LPA ref: FP/21/17/PL

Our ref: HA/2017/119232/01-L01
Your ref: FP/21/17/PL
Date: 03 April 2017

1 NO. DWELLING WITH DETACHED GARAGE TO FRONT.

31 RIFE WAY, FELPHAM, PO22 7BN.

Proposals Plan - Scale 1:500

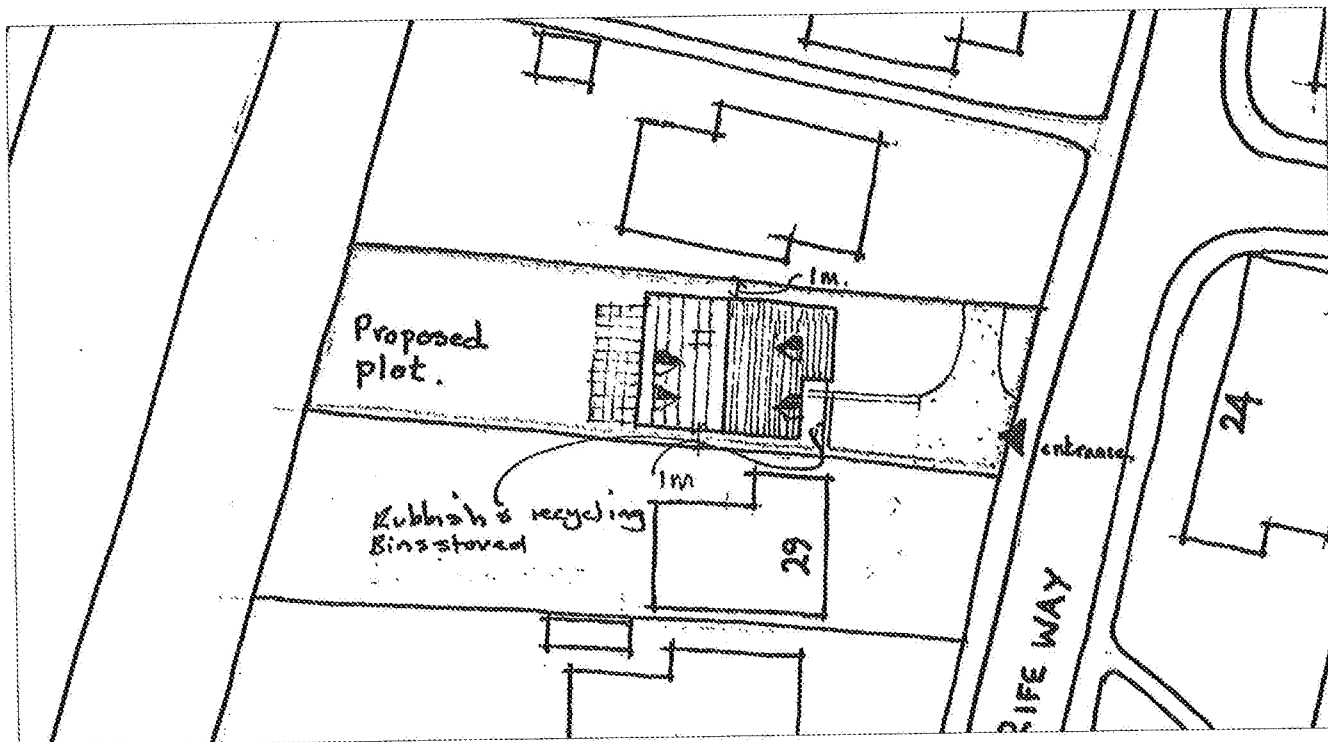
1. Finished floor levels are set no lower than 2.3m above Ordnance Datum (AOD).
2. The mitigation measures shall be fully implemented prior to occupation and subsequently in accordance with the timing / phasing arrangements embodied within the scheme, or within any other period as may subsequently be agreed, in writing, by the local planning authority.
